From:
Sent: 26 July 2026 12:16
To: Katie Chew
Cc: DC Admin
Subject: Objection to Planning Application 2026/91657 – Plot 23, Lingards Road - The Decisive Test

I am writing concerning planning application 2026/91657.

The Decisive Test: Would This Plot 23 Have Been Approved?

Lower Ground Floor (1:100)

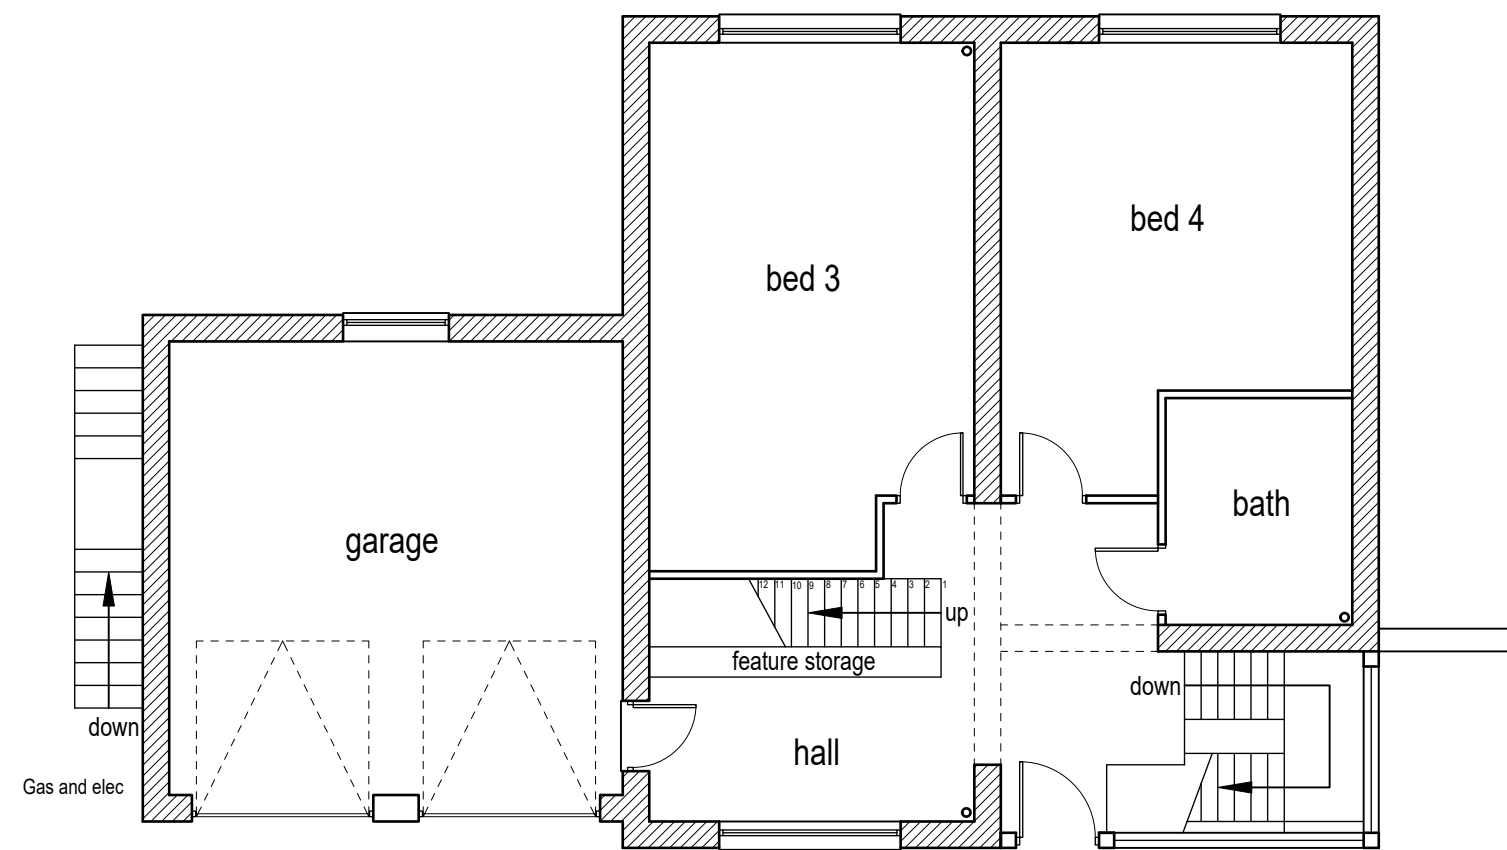
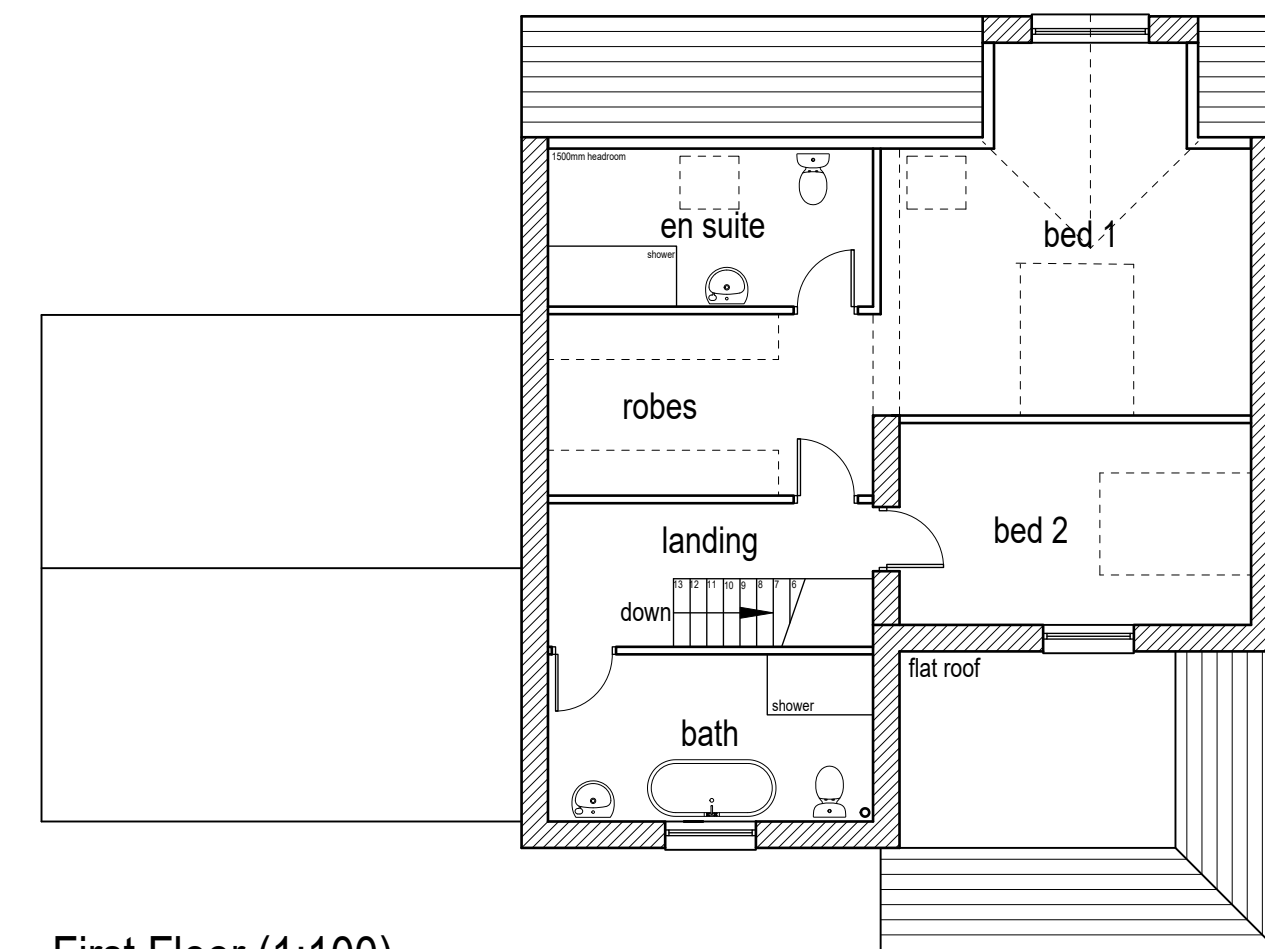
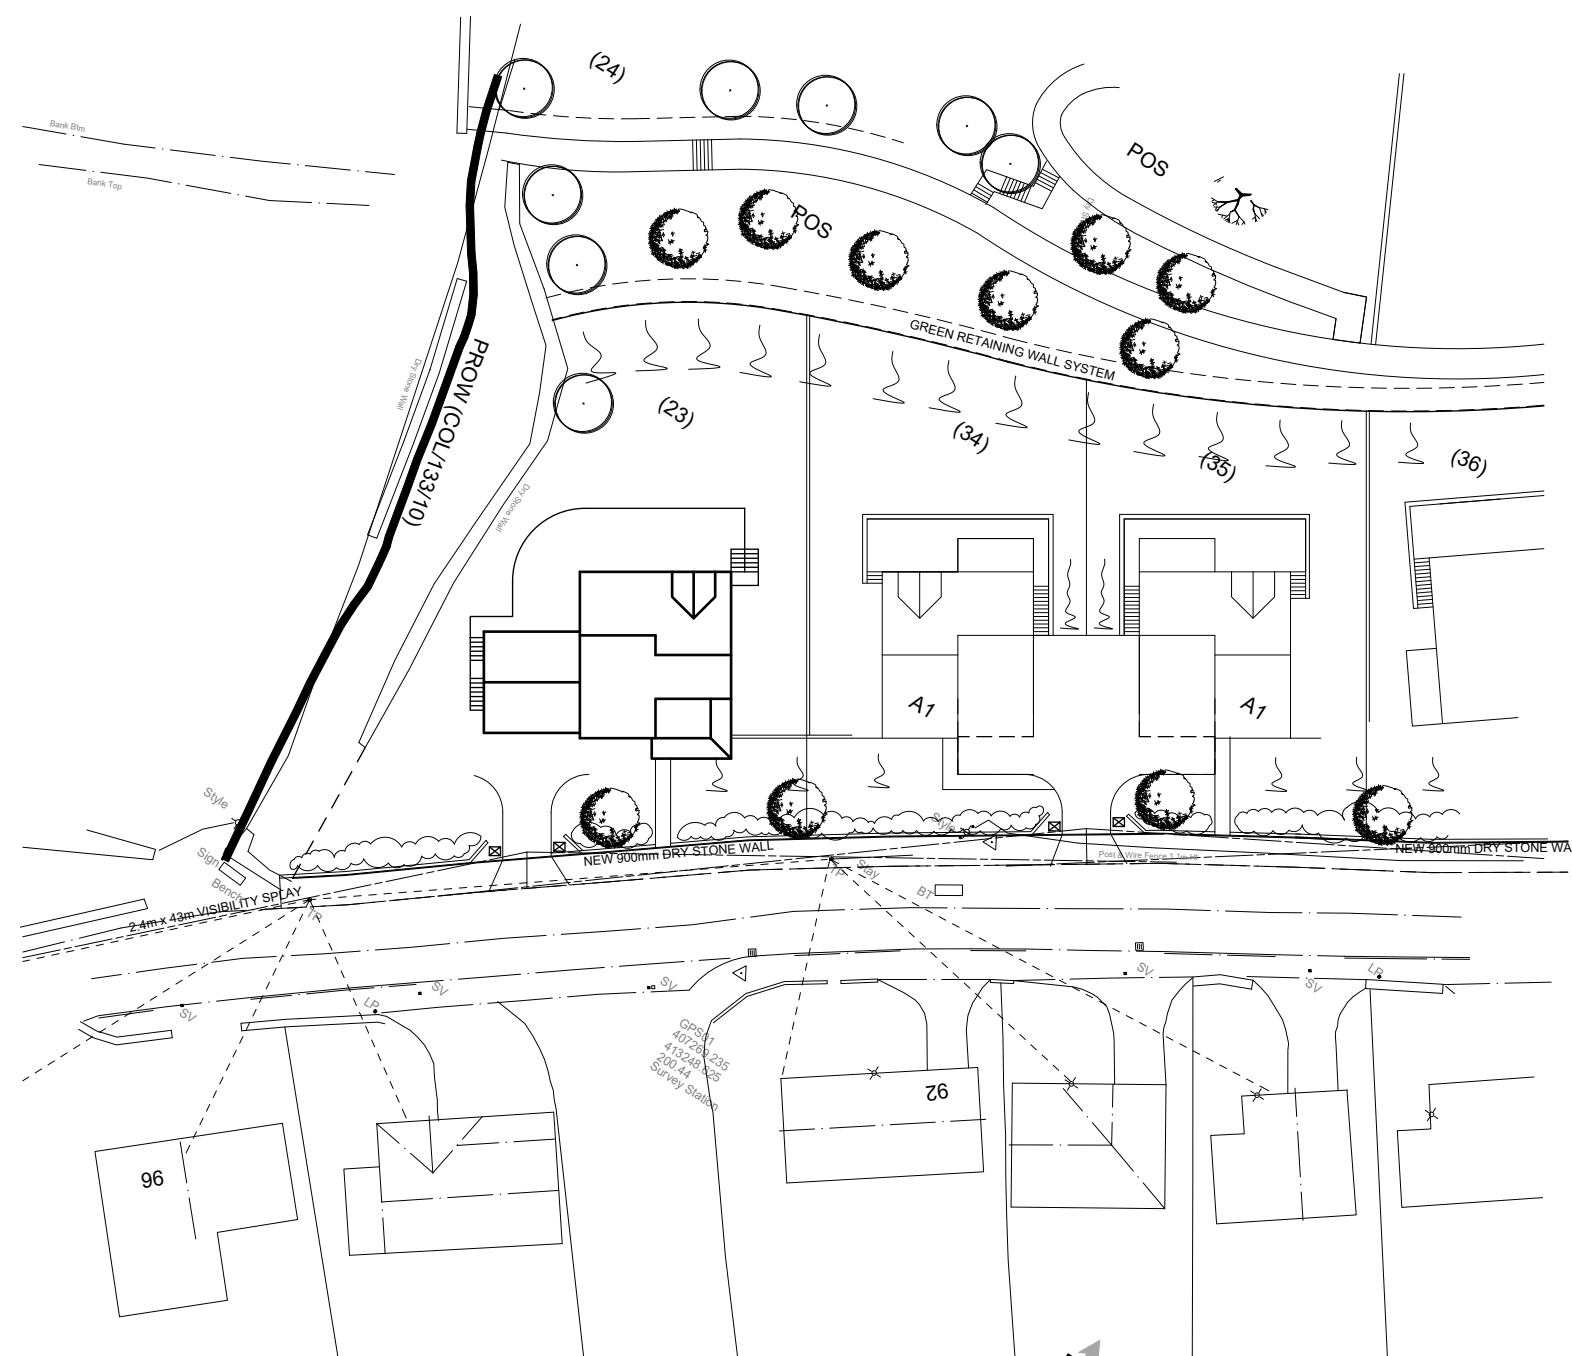
2020/93954 approval reasoning	Latest Plot 23 design	Consequence
The original 57-dwelling scheme was considered overdevelopment because of the site's constraints. The revised scheme became acceptable after reducing development, retaining structures and dwelling prominence.	Plot 23 now combines a double-width garage, substantial raised patio, garden room, store, basement void and enlarged multi-level dwelling.	It reintroduces concentrated overdevelopment at the most sensitive individual plot.
The report says the dwellings were individually designed to keep their heights "to a minimum".	The plan contains four separate floor plans: Basement, Lower Ground Floor, Ground Floor and First Floor.	This is fundamentally different from the height-limiting design described in the report.
Downhill elevations were described as two or three storeys. Where three storeys occurred, the upper storey was principally incorporated into the	The rear elevation reads as four external levels: the basement/store/garden-room level, lower-ground floor, ground floor and roof-level first floor.	Although the upper floor remains partly within the roof, another externally expressed level has been created beneath it, defeating the mitigation relied upon in the report.

NOTE:
Design retaining wall for 2900mm storey height.

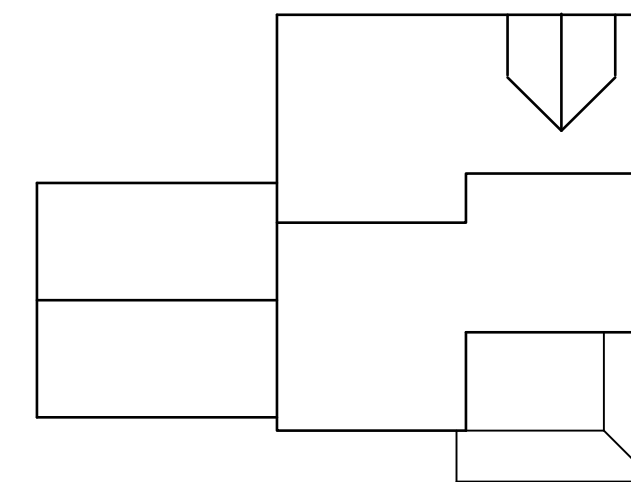
Retaining walls had been “kept to a minimum”, with the split-level houses themselves helping to retain the land.	The latest drawing instructs that the retaining wall be designed for a 2,900mm storey height , together with a basement void and large raised patio over the lower accommodation.	The retaining operation is no longer incidental landscaping; it facilitates an additional building level.
The report concluded that atypical features would not “define or dominate” the development.	The rear elevation is exceptionally large, with three wide banks of glazing and doors at its lower levels, while the double garage substantially widens the frontage.	Plot 23 becomes an atypical and dominant exception rather than a restrained variation within the development.
Permitted-development rights were removed because, given the topography, even later extensions or outbuildings could “notably affect the quality of the design”.	The 2026 design introduces substantially more built form than an ordinary domestic extension would have done.	If ordinary extensions were considered too harmful to leave to permitted development, approval of considerably greater built form through successive variations cannot reasonably be reconciled with that safeguard.
